March 12, 1981

Re: 1008 Congress St.

On March 10, 1981, a fire occurred at the above mentioned address which required an inspection by the Fire Prevention Bureau and the Building Inspection Dept. This structure contained a mix of occupancies which makes it impractical to provide separate safeguards for each type of occupancy. The various types of occupancies are: residential, educational and public assemblage; therefore, the following requirements shall be met before approval can be given to occupy this structure.

# Second Floor

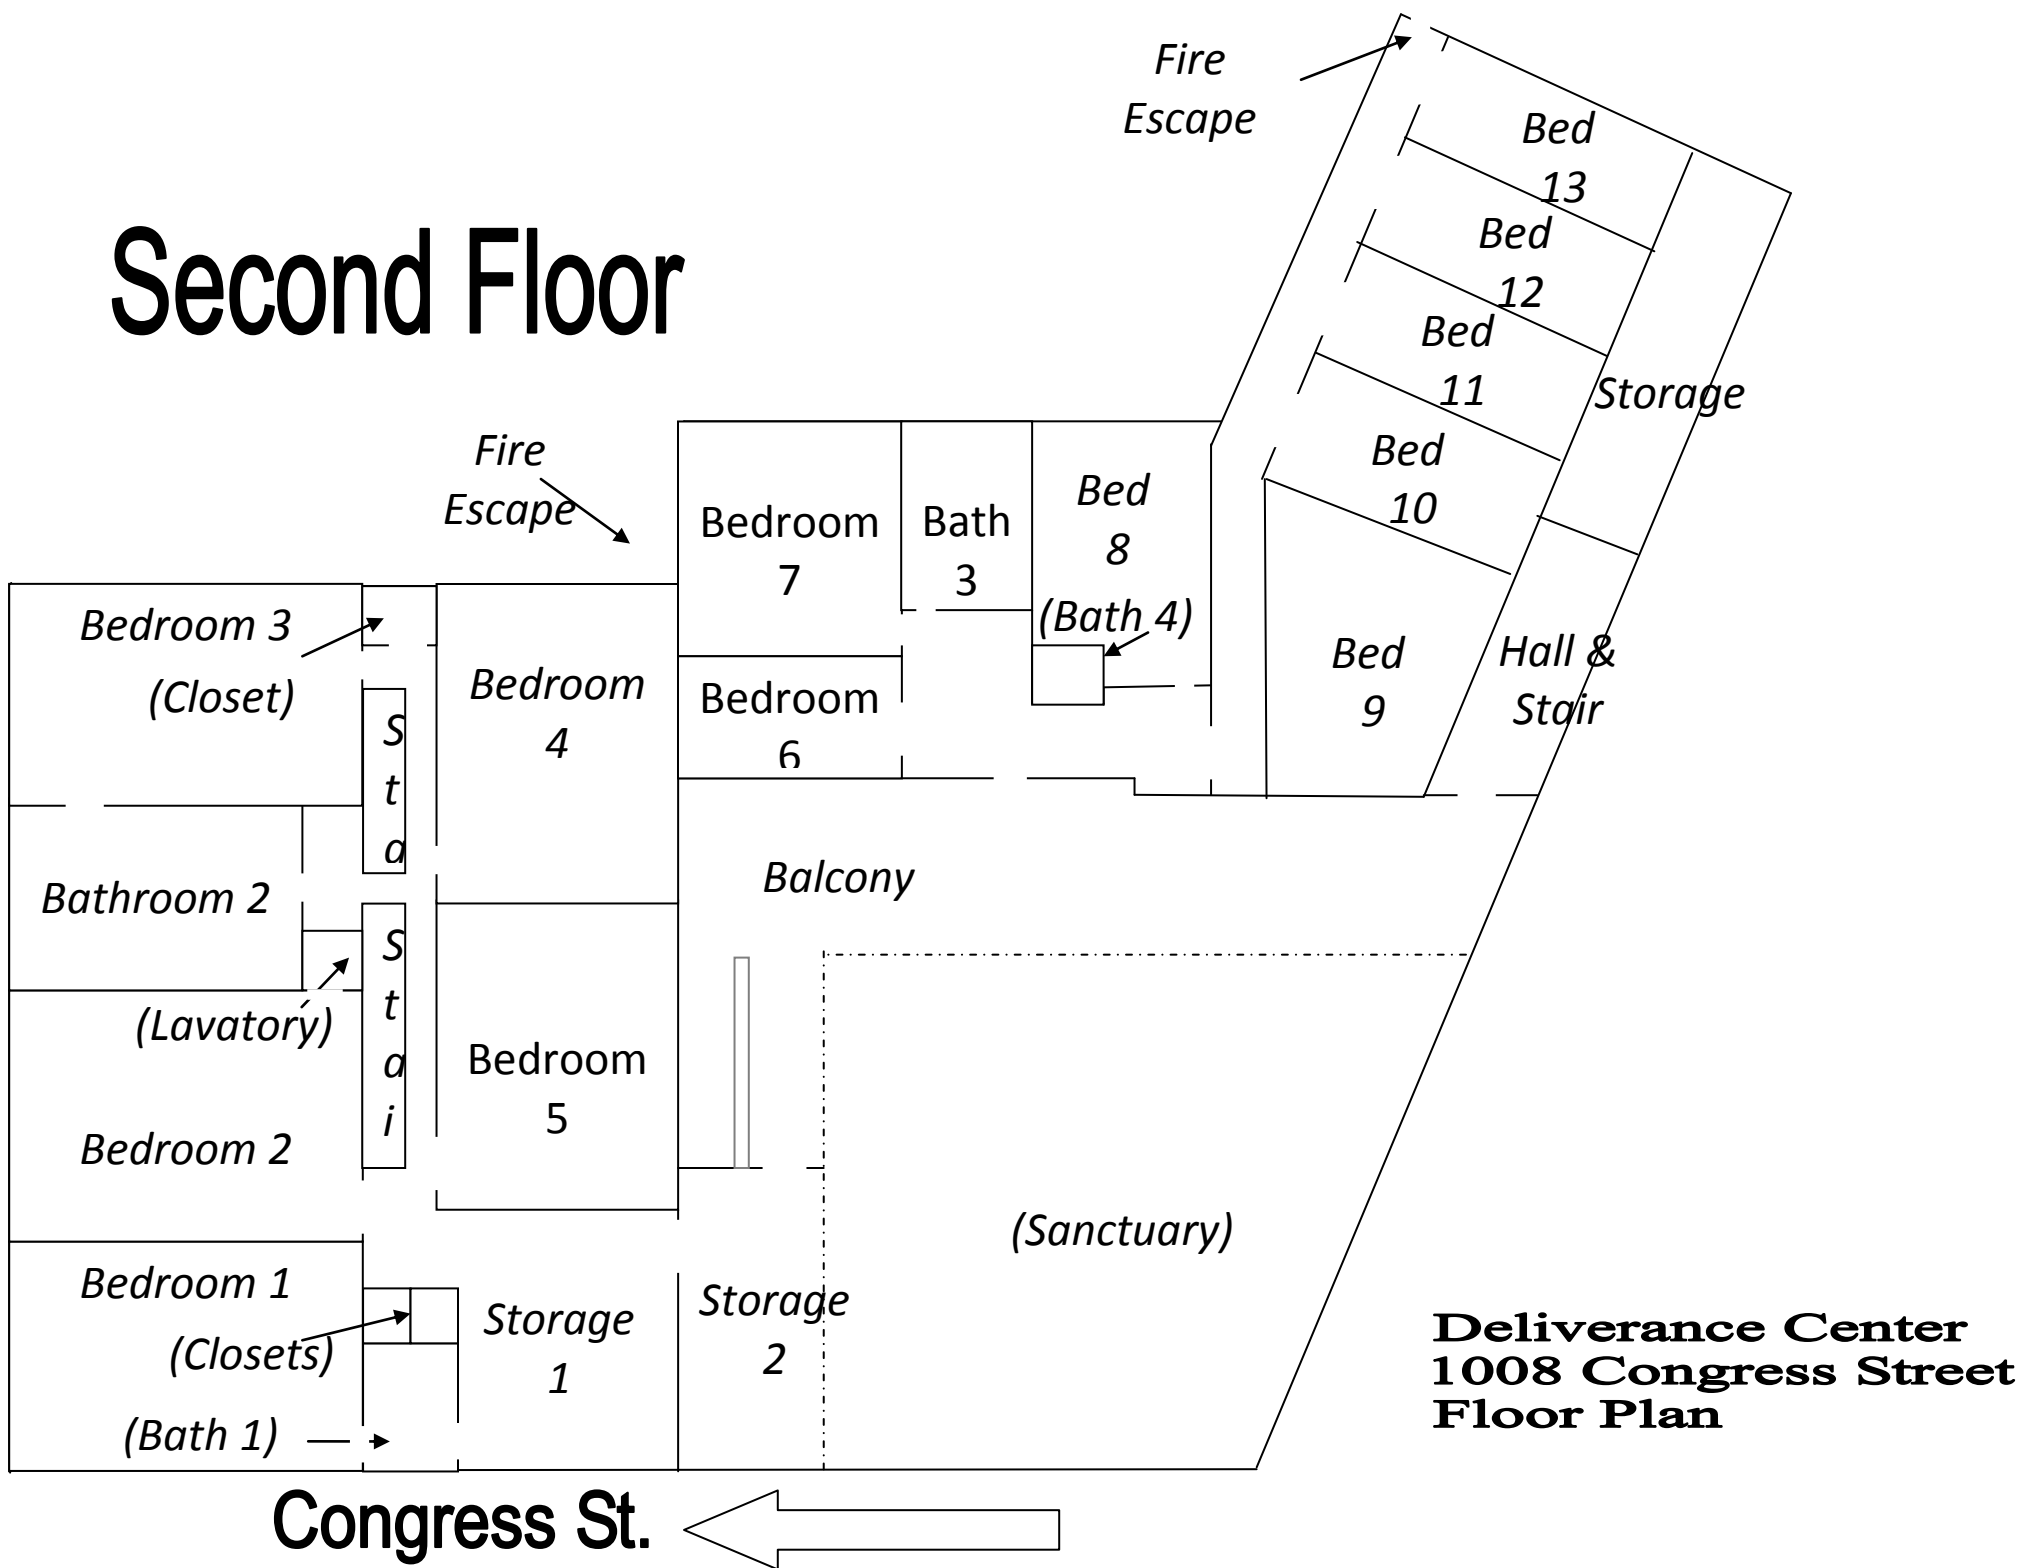
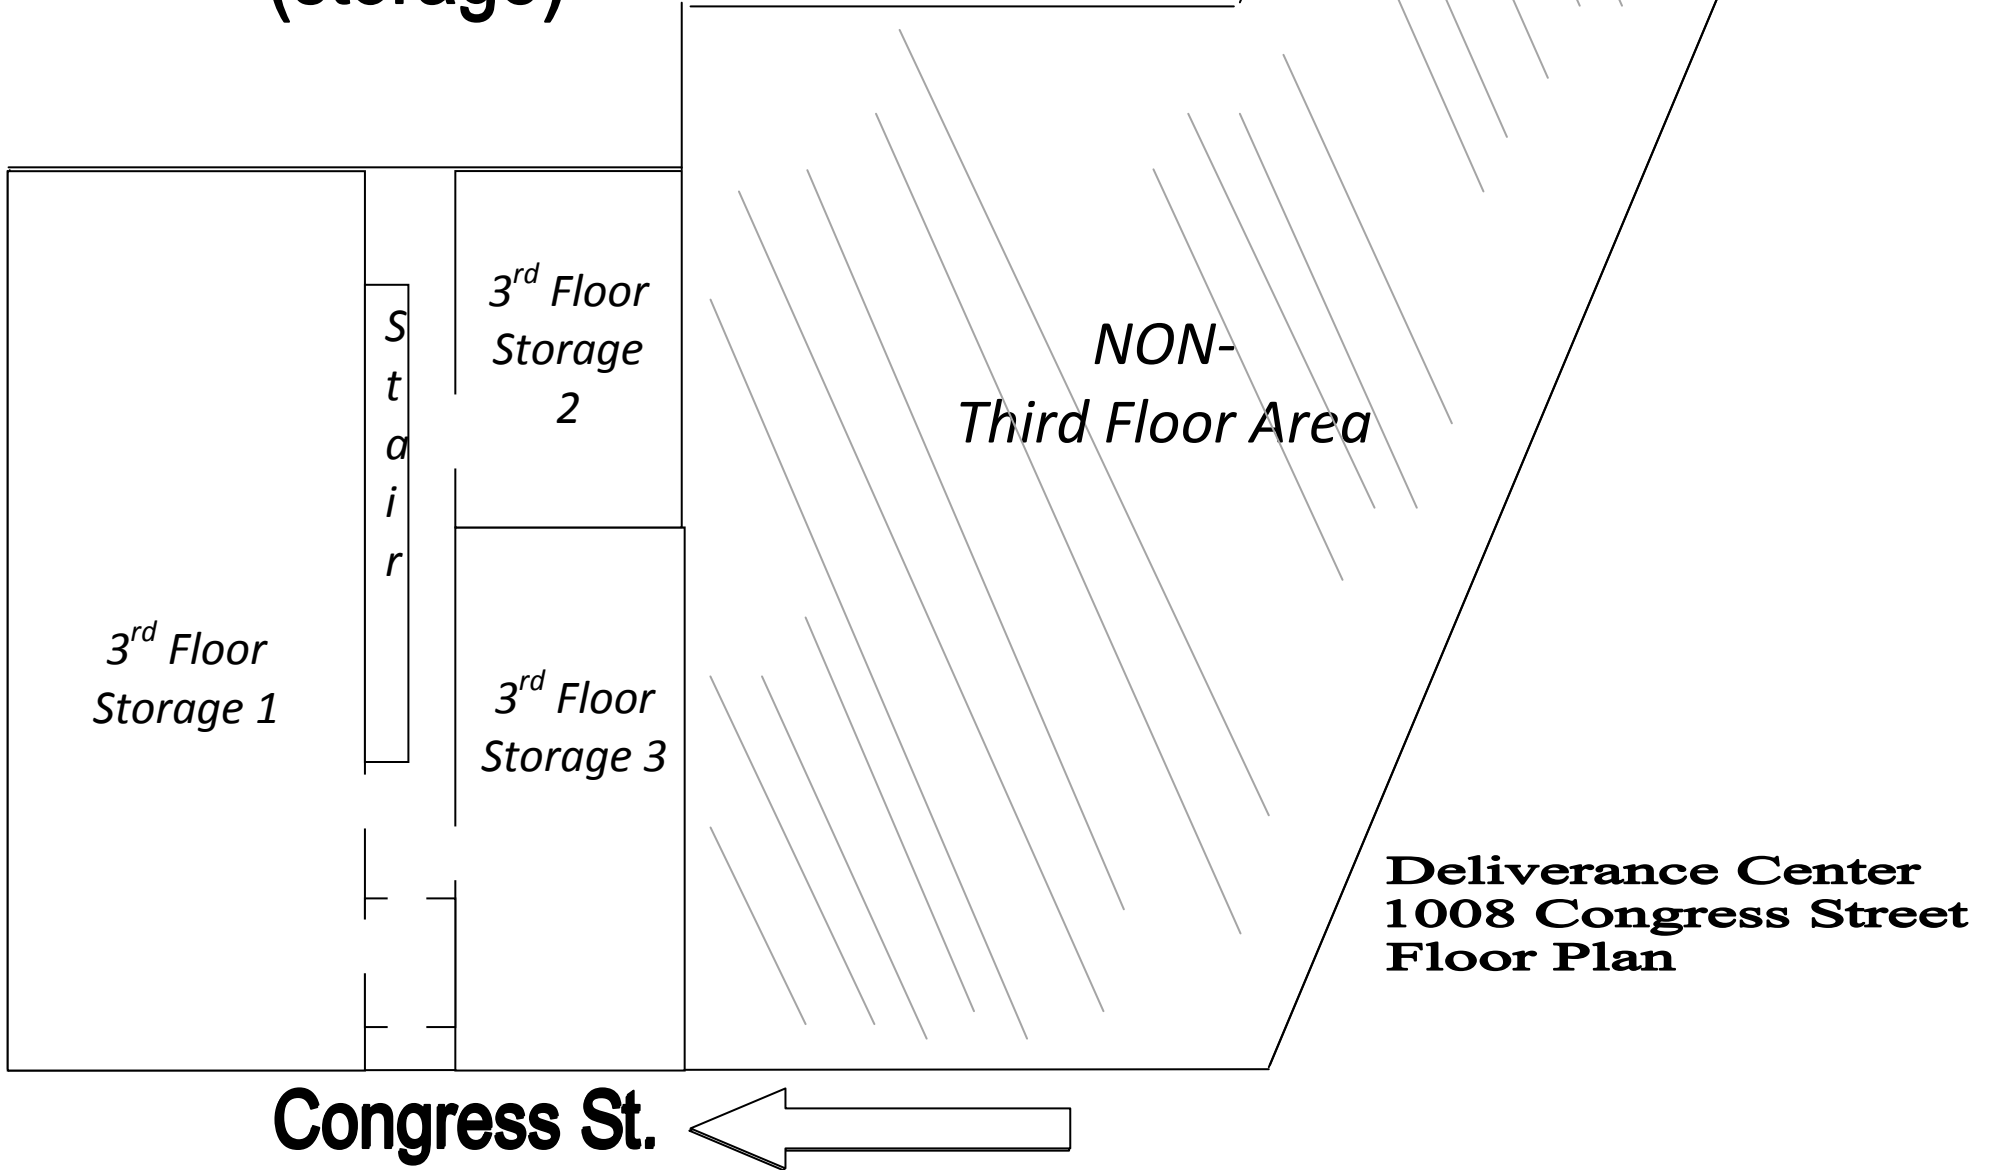
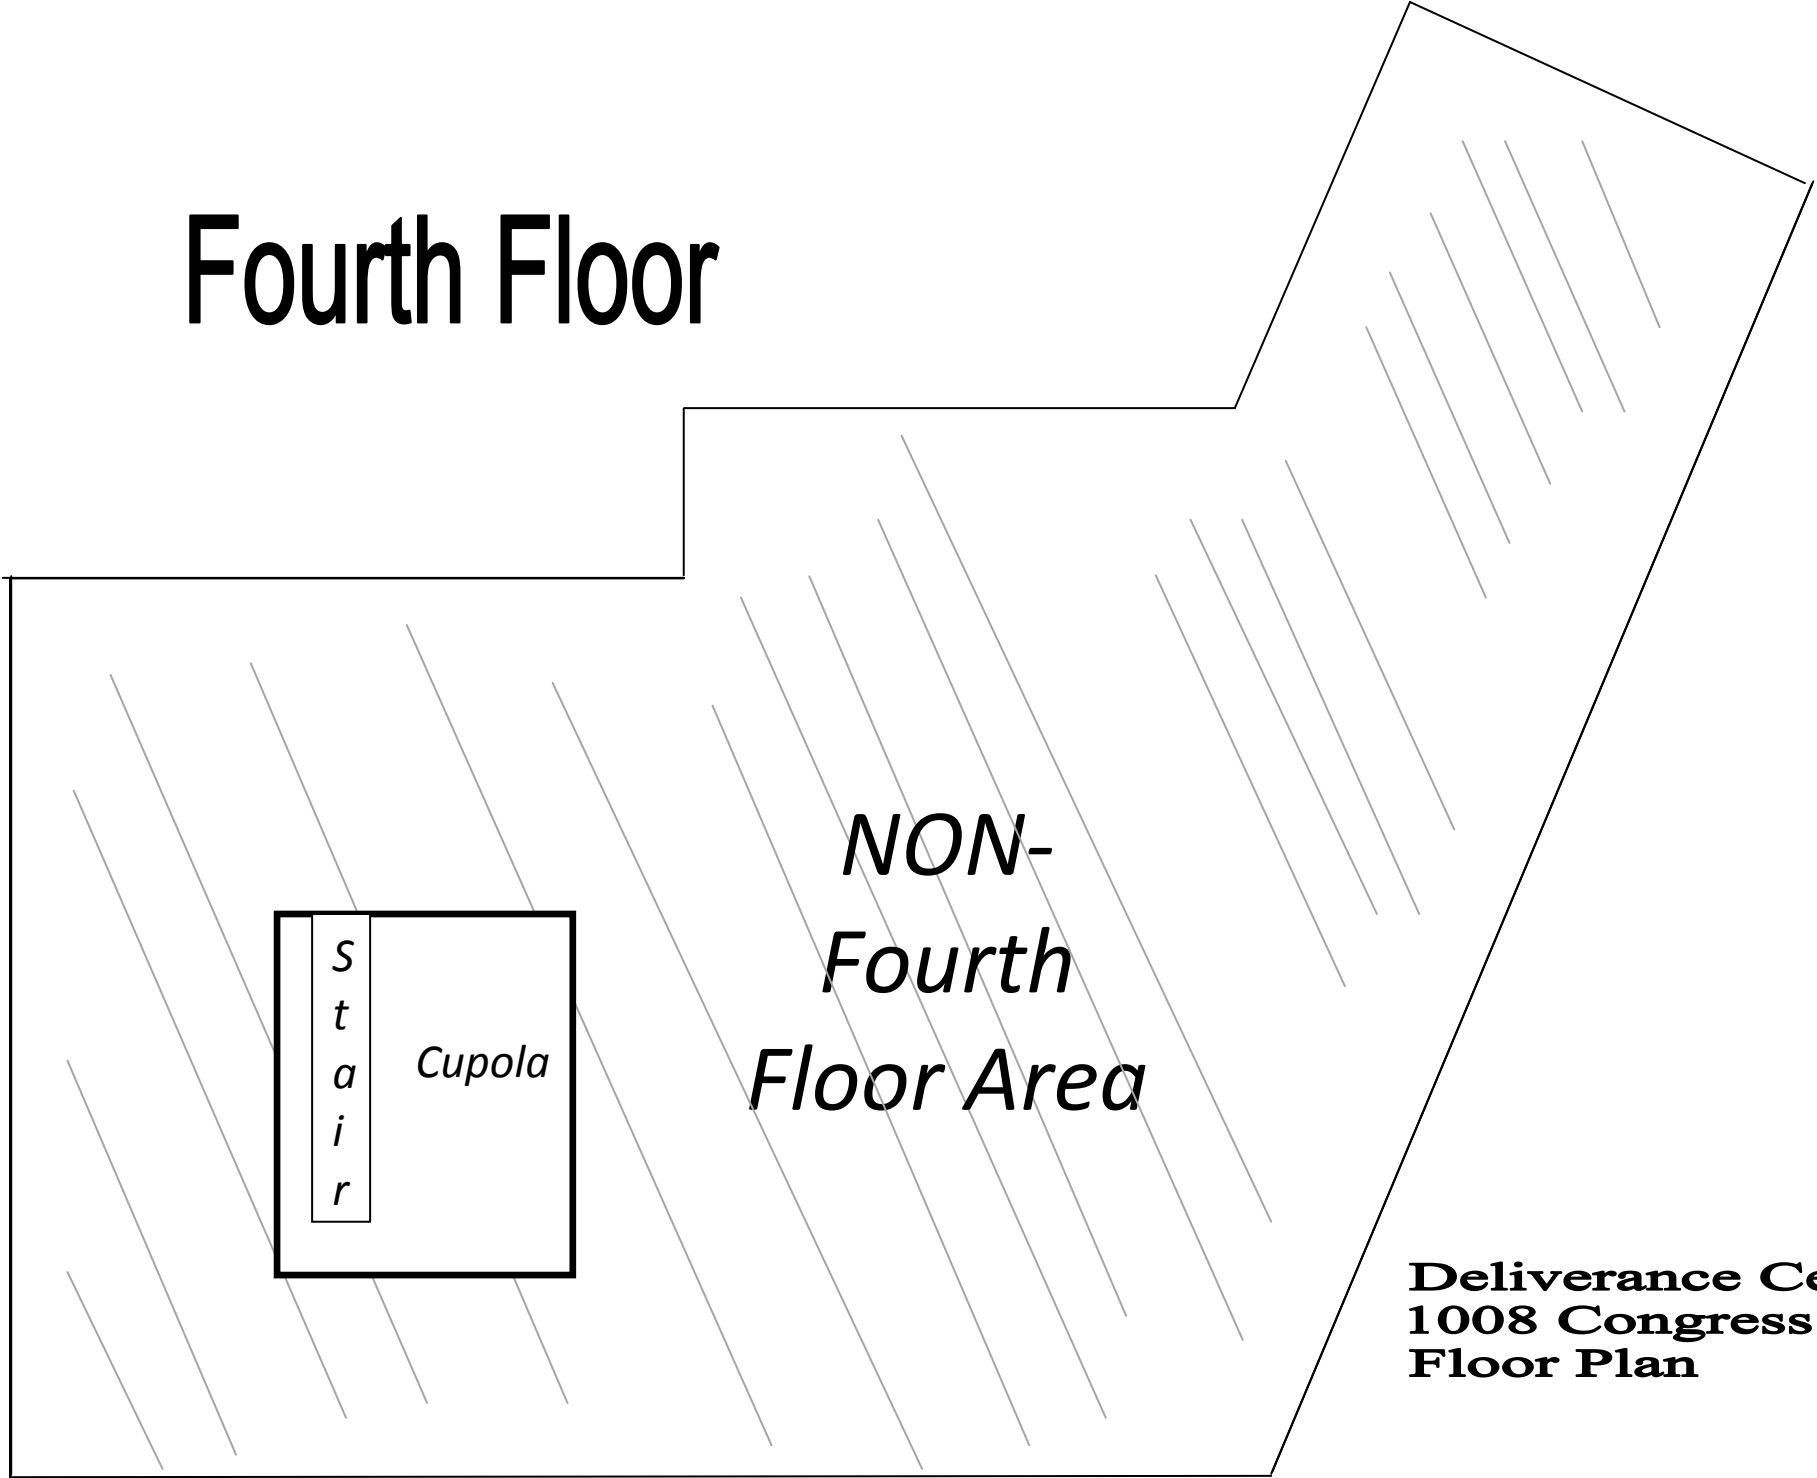
1. Provide two separate and remote approved exits for each area of each floor. Exits shall terminate at the exterior of the building at ground level.
2. Enclose all vertical openings with construction having a fire rating of at least one hour including fire doors with self closers.
3. No education or public assemblage occupancy shall be permitted below grade level.
4. Provide an approved automatic fire alarm system throughout the building.
5. Provide an approved sprinkler system throughout the basement level.
6. Provide emergency lighting and illuminated exit signs for all exits and paths to reach same.
7. Provide a one hour fire rated enclosure for the boiler room.
8. All wood stoves not complying with the enclosed wood stove ordinance (Chapter 324) shall not be used until they conform to code.
9. A general clean up of all areas to remove flammable accumulation is required.
